From: Anita Gardner
Sent: 12 April 2019 11:48
To: Planning.Responses
Subject: FW: Rustington s73

Subject: Rustington s73

222-A-x-SP-02

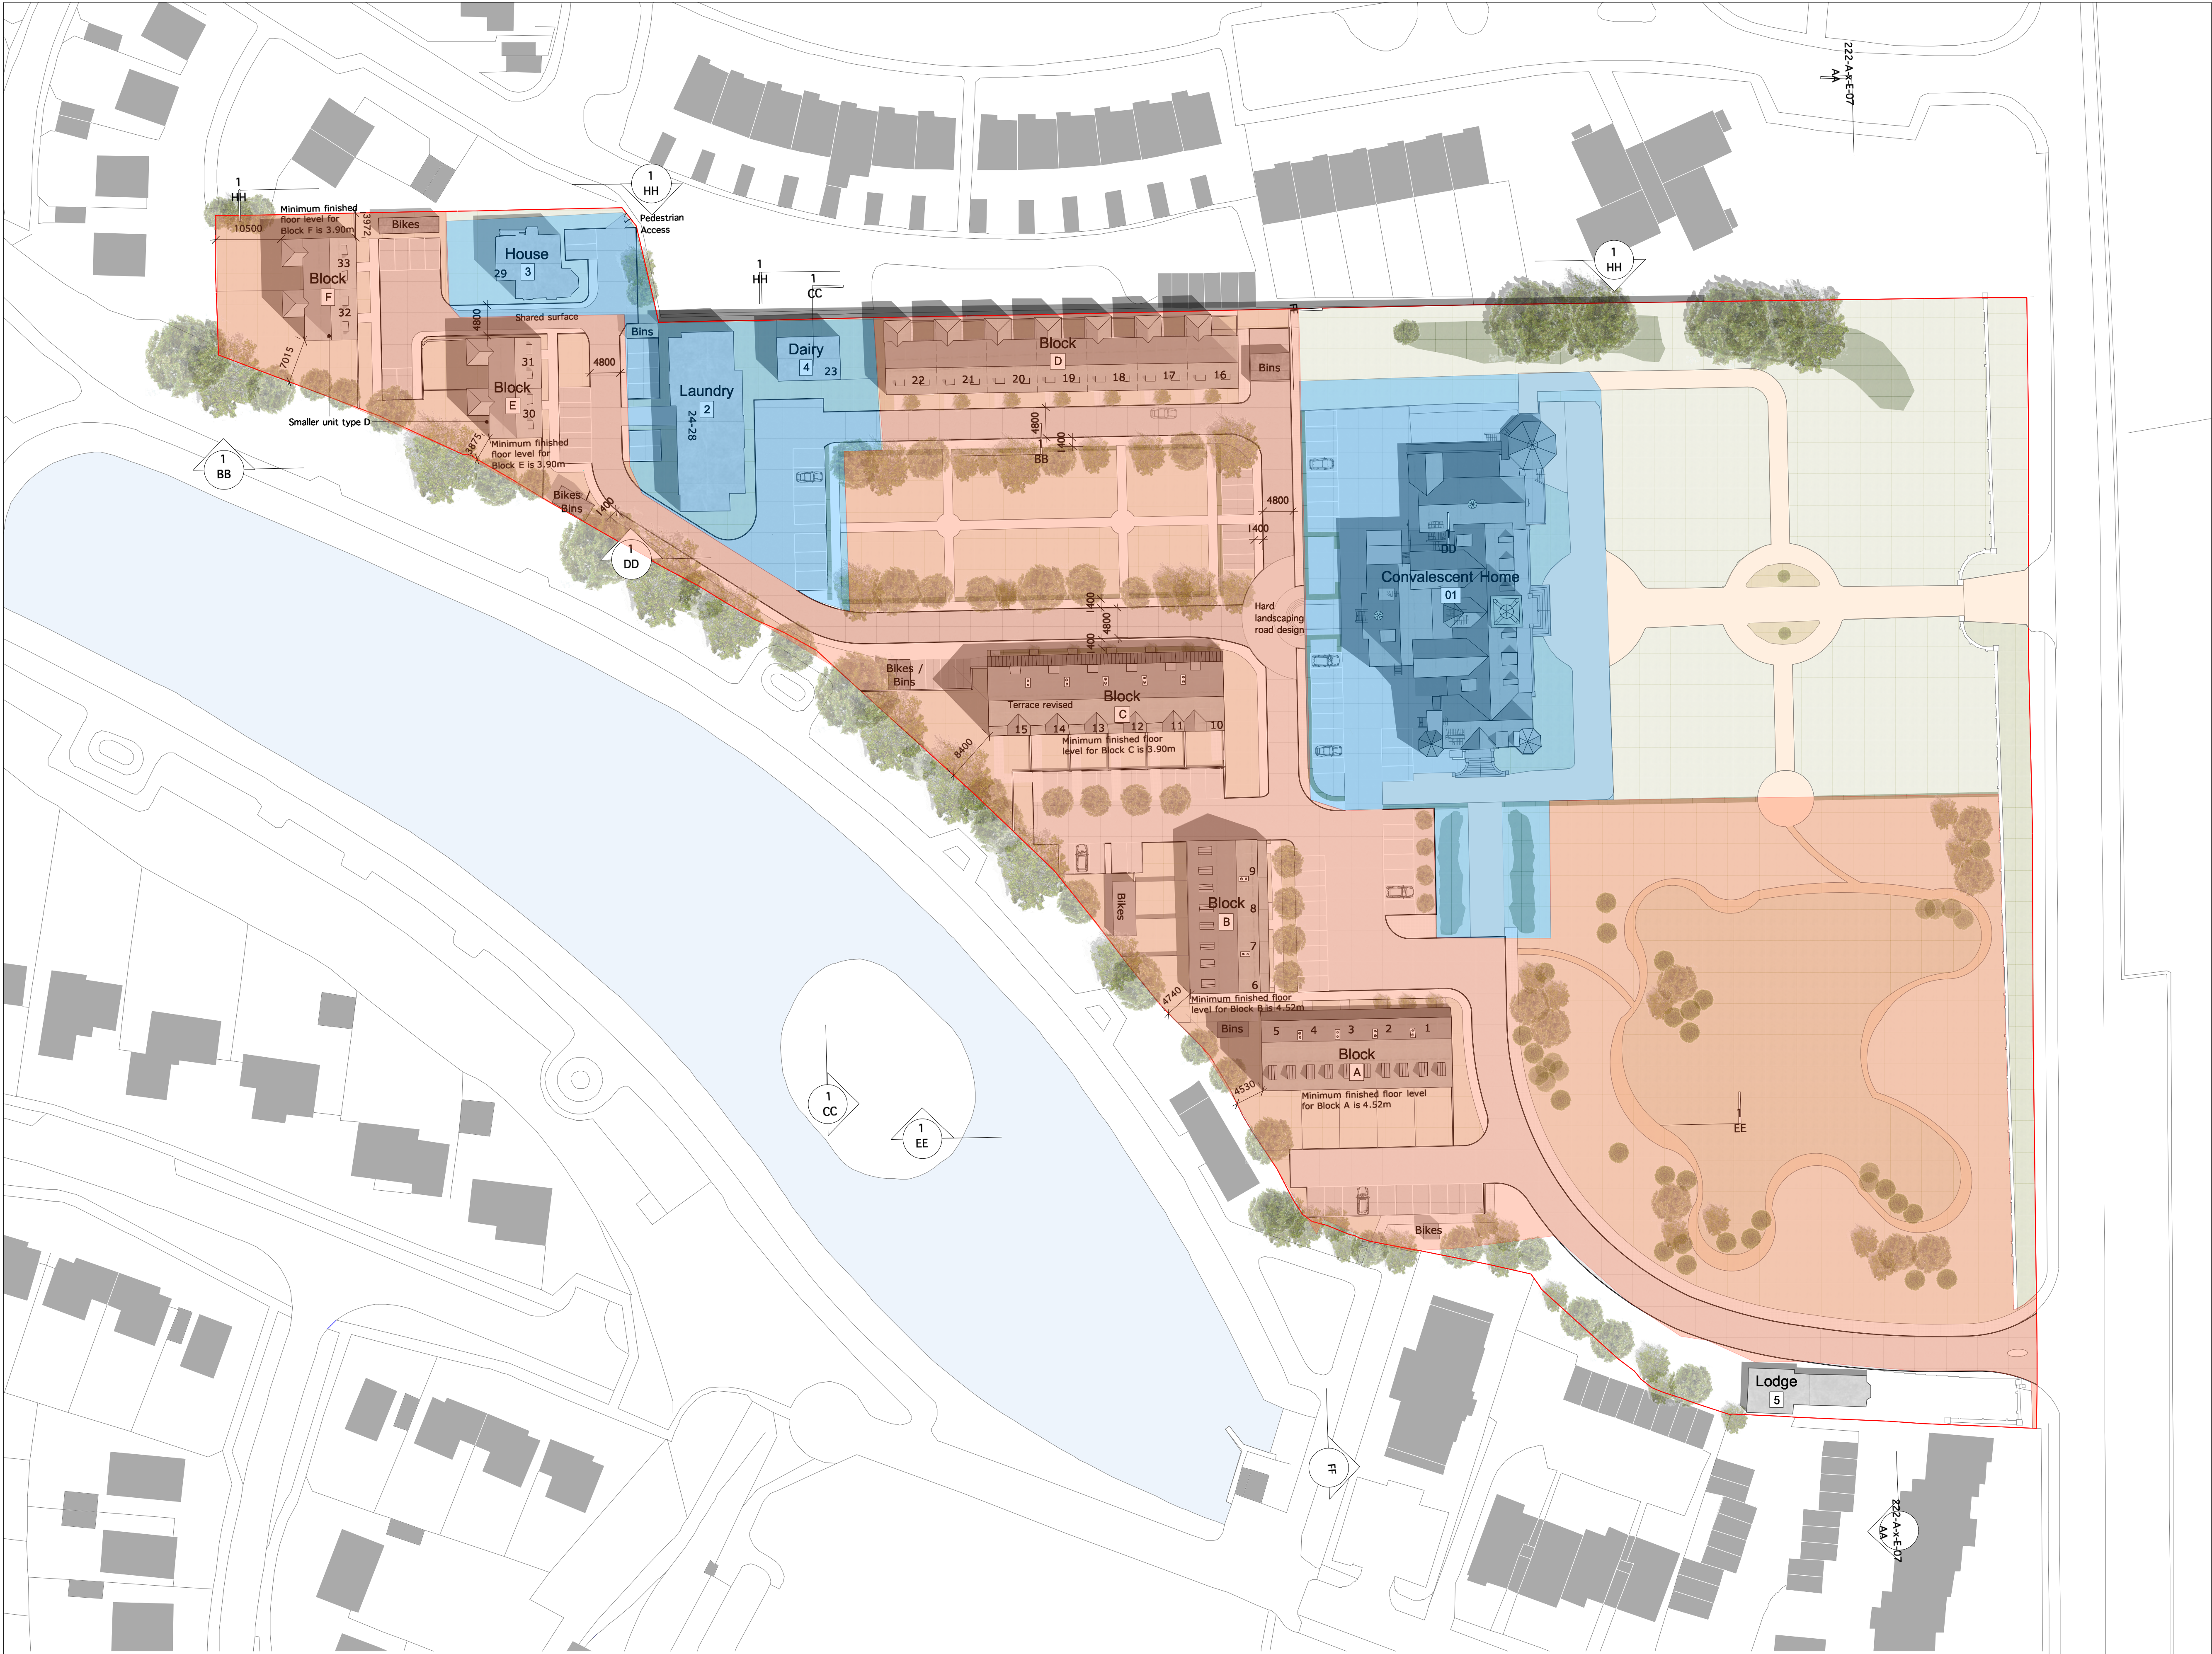
Thank you. Re condition 2 the latest phasing plan submitted with the application is 222-AX-SP-02 N.

(in your draft it is listed as 222-A-x-SP-01 rev M).

2 The development hereby approved shall be carried out in accordance with the following approved plans location, 222-A-I-P-00, 222-A-I-01, 222-A-I-P-02, 222-A-I-S-00, 222-A-I-E-00, 222-A-I-E-01, 222-A-I-E-02, 222-A-I-E-03, 222-A-x-SE-00, 222-A-D-E-00, 222-A-E-P-00 revA, 222-A-x-SE-01 revB, 222-A-x-SE-02 revA, 222-A-2-EXP-00, 222-A-2-P-00, 222-A-A-P-00 revB, 222-A-B-P-00 revB, 222-A-C-P-00 revA, 222-A-D-P-00, 222-A-D-E-00 revA, 222-A-EP-00 revA, 222-A-X-SP-01 revK, 222.901, 10631012 Basement, Ground, First and Second Floor plans of Home, floor plans and elevations of The Cottage, Carpenters Home, 281/700, 281/100 rev9 and 281/101 revB and phasing plan 222-A-x-SP-01 rev M.

The internal roads appear to be very narrow, 4.8m wide in some sections (including footways/verge) e.g. at block E. It would be helpful for the designer to dimension the drawing, i.e. give widths of carriageways, verges, footways etc. The carriageway looks even narrower around Block C.

These amendments have been made. I note that we have not yet agreed a further EOT to allow for signing of the S 106. Can you confirm your acceptance by return until next Monday 15-04-2019.
